Our Ref: HE551519-ATK-GEN-LN-XM-000016

**M25 junction 28 improvement scheme
Planning Inspectorate reference: TR010029
Notification of intention to make a request for an additional change to the
Scheme (Change 8 – Grove Farm egress) and clarification regarding Work No.
7 (Extent of M25 carriageway works)**

Change 8 – Grove Farm egress – revisions to Work No. 15

**Fig 3.1 - HE Indicative alignment of amended Grove Farm egress (Change 8)**

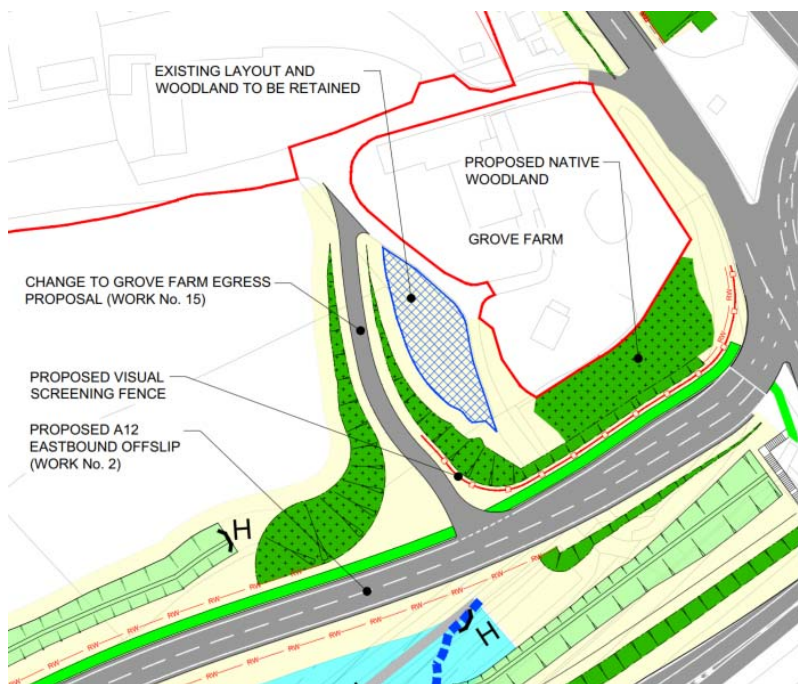
Representations received from Grove Farm expressed concern about the proximity of the realigned A12 eastbound off slip-road (Work No. 2) and the proposed Grove Farm egress (Work No. 15). Highways England acknowledges that the owners are concerned that this will have a detrimental impact on their amenity as it may result in lorries queueing on the egress outside their residential property as they approach to join the new A12 eastbound off slip.

To deal with this concern Highways England engaged with the owners’ agent and are developing an option which involves re-positioning the egress road (Work No. 15) slightly further away from the property to mitigate their concern.

Change 8 would require additional land outside of the highways limits of deviation as shown on the Works plans (APP-006). However, The Infrastructure Planning (Compulsory Acquisition) Regulations 2010 would not be fully engaged as the additional land required is needed for temporary possession only.
